DWIRE YARD - GRADING AND EROSION CONTROL PLAN

EL PASO COUNTY FILE NO. MS 20-002

GRADING AND EROSION CONTROL PLAN

## VTC-3. VEHICLE TRACKING CONTROL W/ CONSTRUCTION MAT OR TURF REINFORCEMENT MAT (TRM)

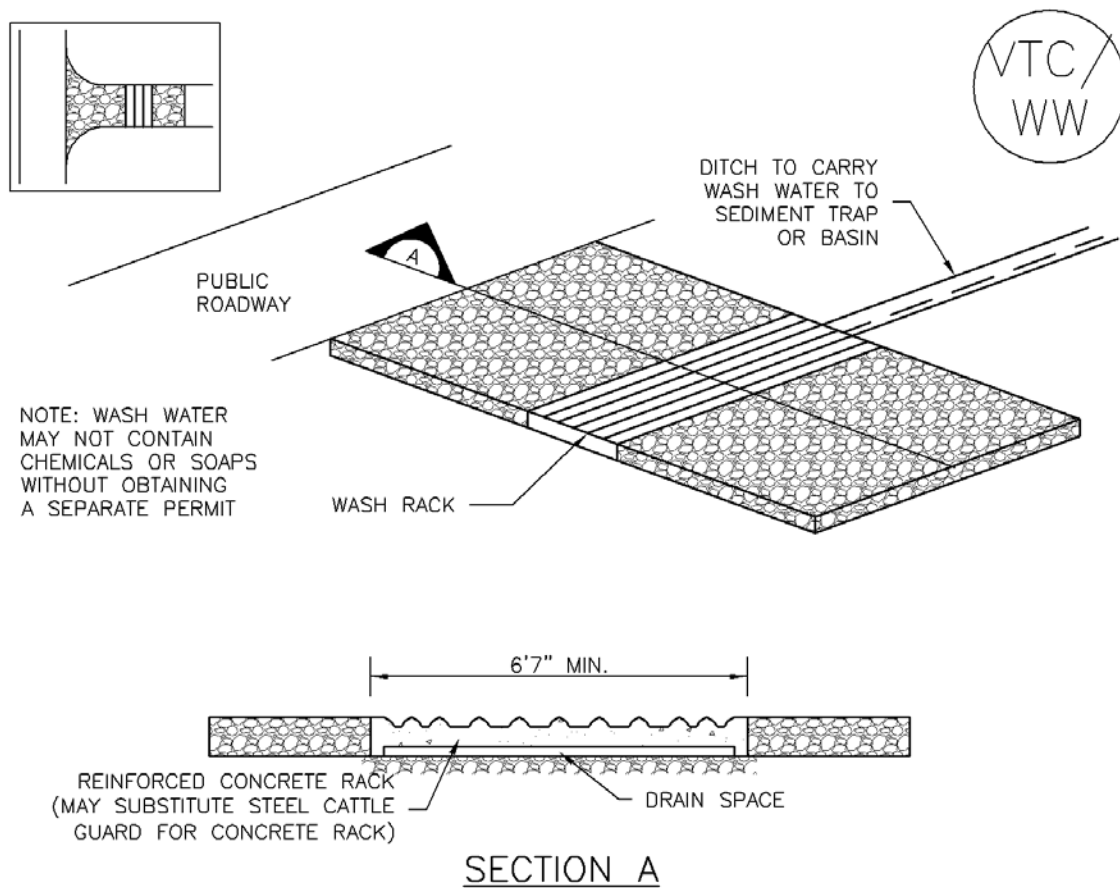
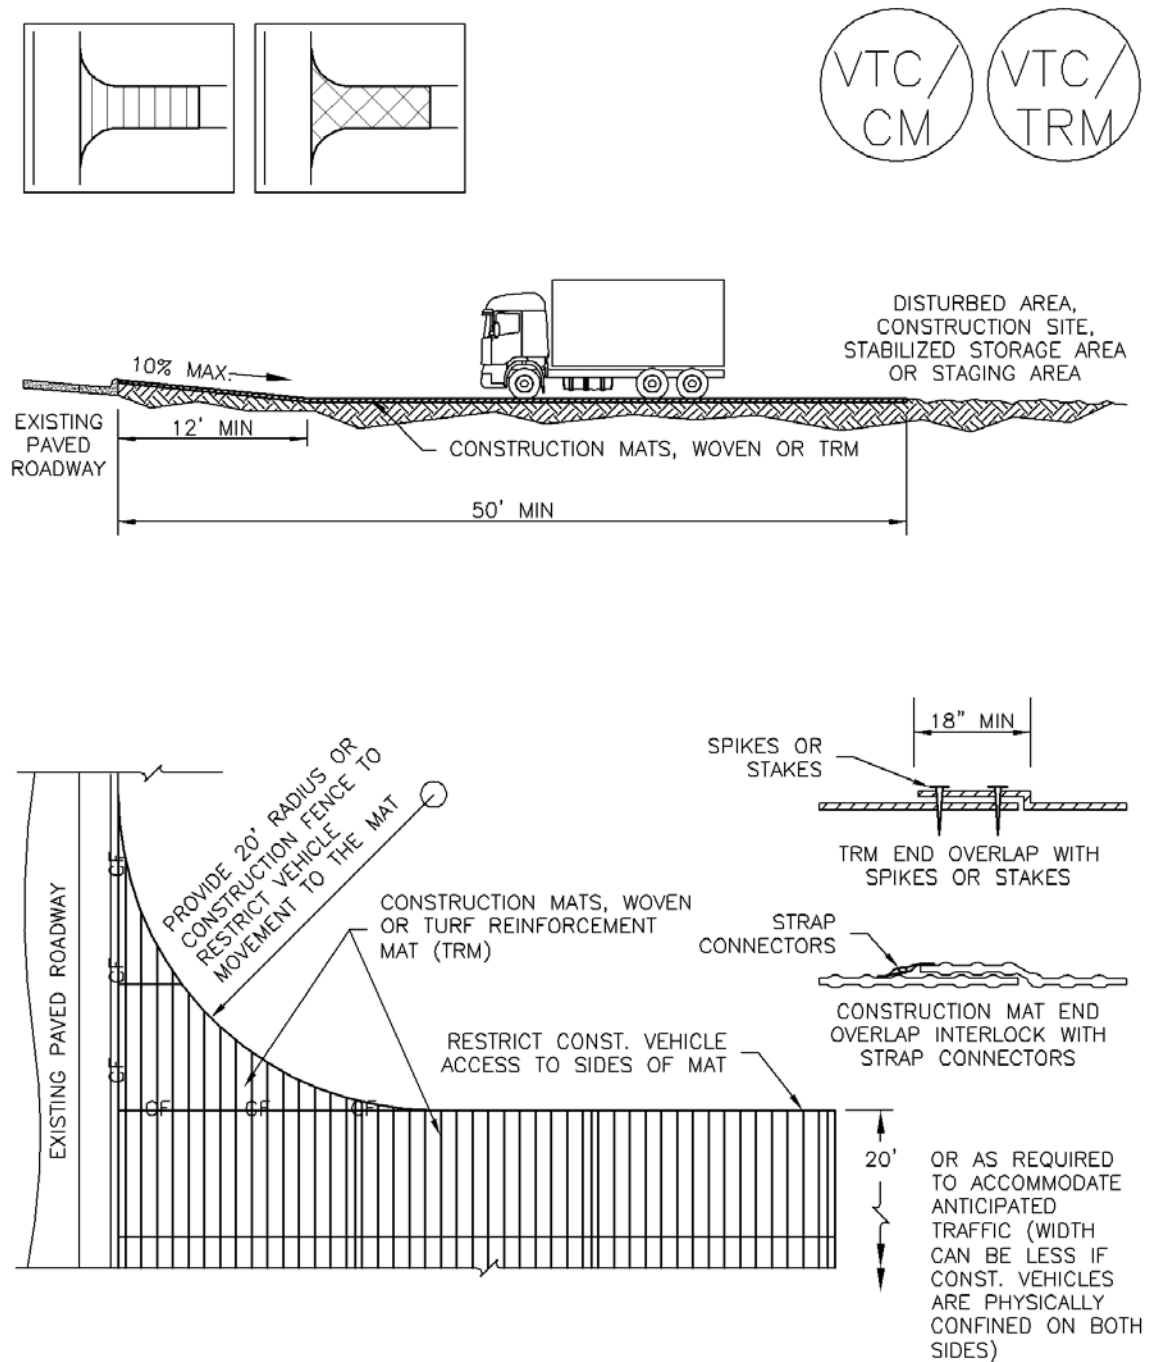
replace with EPC
approved VTC detail
(DCM Vol. 2)
Unresolved.
